Subject: RE: Planning Consultation on FP/42/19/DOC

Engineers Comments Regarding Condition 7

NB: Sub-base construction depths are shown as minimum construction requirements. Specific construction depths vary, e.g. where sub-base falls (to collection point) in opposite direction to surface falls. See respective Drainage Layout for specific sub-base levels.

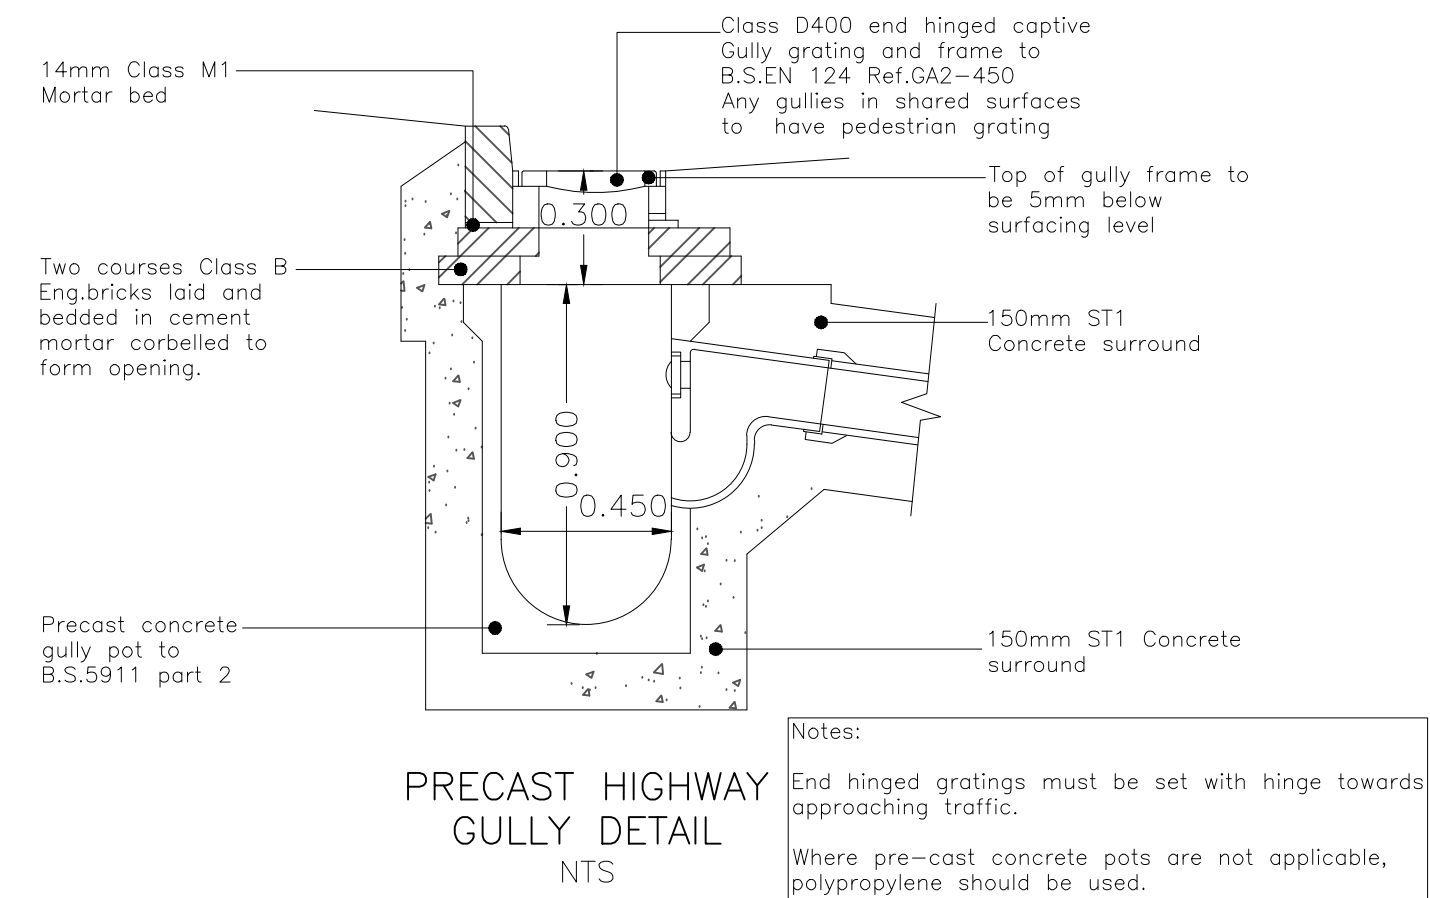
1. Catchpits must be provided upstream of all connections into the attenuation tank.
Please refer to drawing 5782:23 Construction Details demonstrating manhole SW04 and SW05 should be installed with 300mm deep catchpits.
